Your ref: SSD-67588459
Our ref: DOC24/348280

**Subject: BCS response on Environmental Impact Statement for Powerhouse Ultimo
Revitalisation – 500 Harris Street, Ultimo (SSD-67588459)**

BCS response on Environmental Impact Statement for Powerhouse Ultimo Revitalisation – 500 Harris Street, Ultimo (SSD-67588459)

FFL, 1% AEP Flood Level and PMF Flood Level along Harris St and Macarthur St

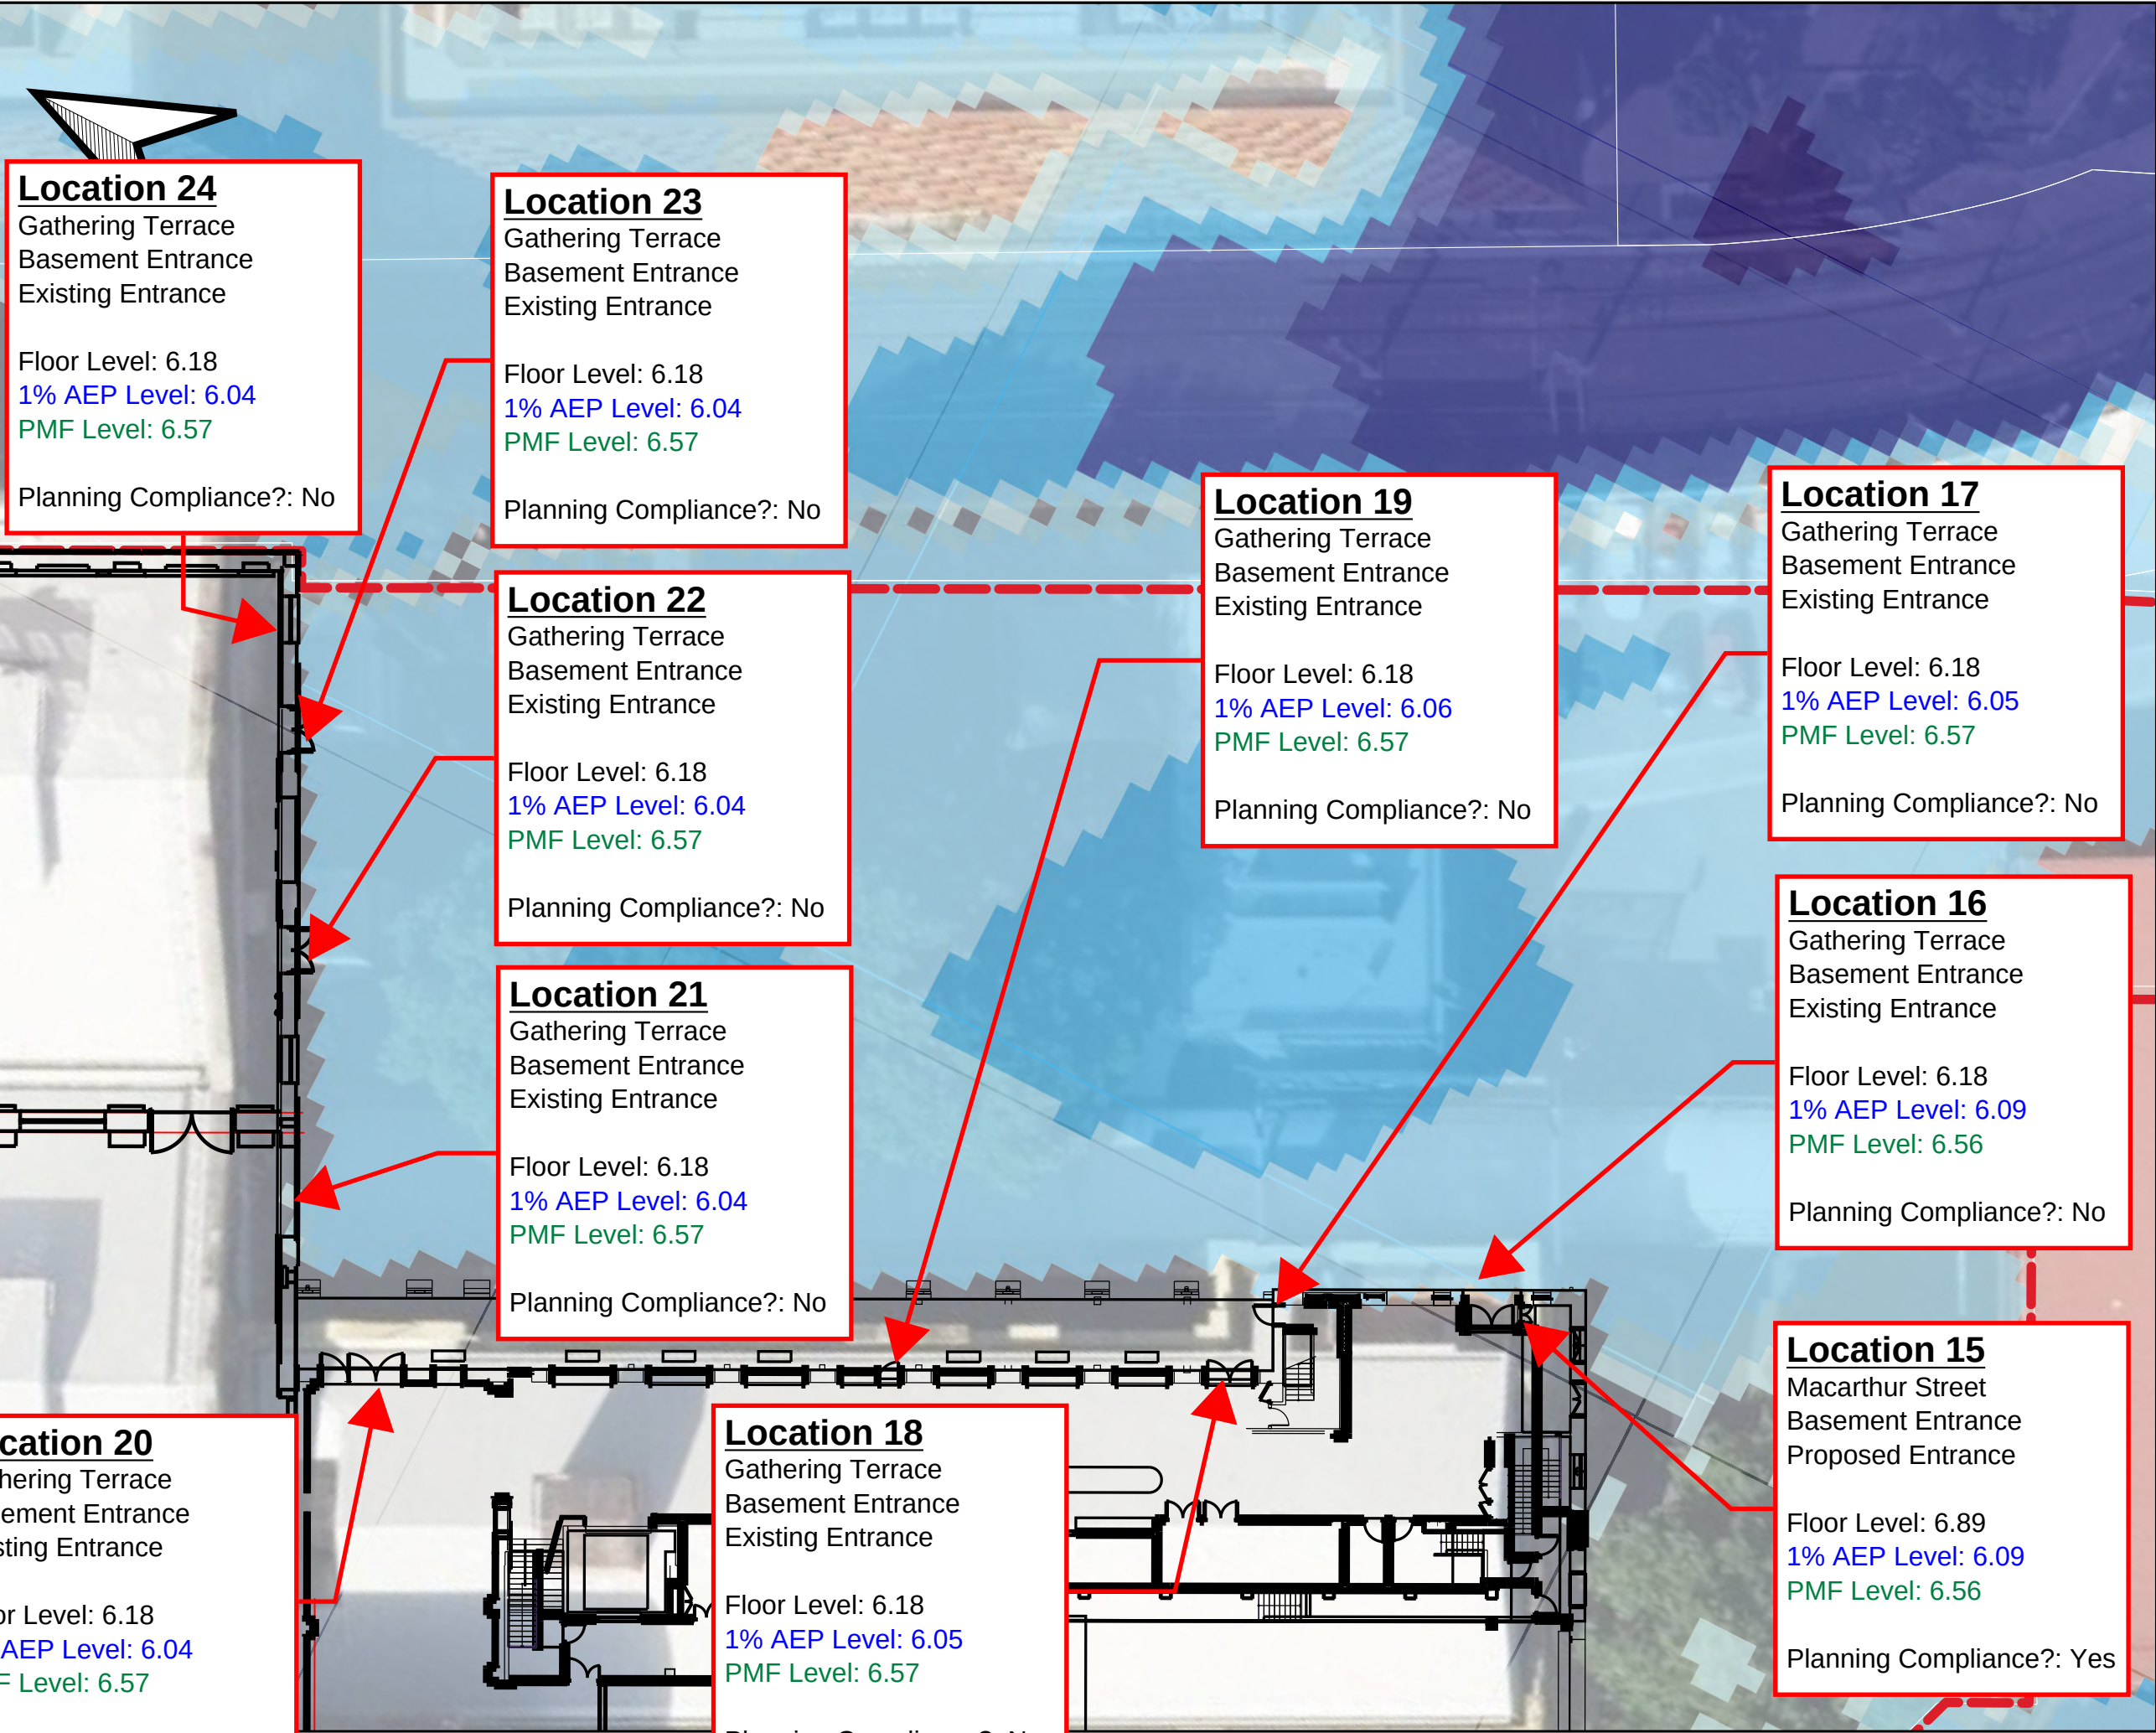
- A plan clearly showing the relevant building entrances together with "flood planning level check locations" shown on Figure 17.
- A description of each location in Tables 15 and 16.
- The water surface levels and depths used to determine flood planning levels should be reviewed against flood depths and levels from a flood model including scrutiny of flood levels adjacent to any new basement entries.
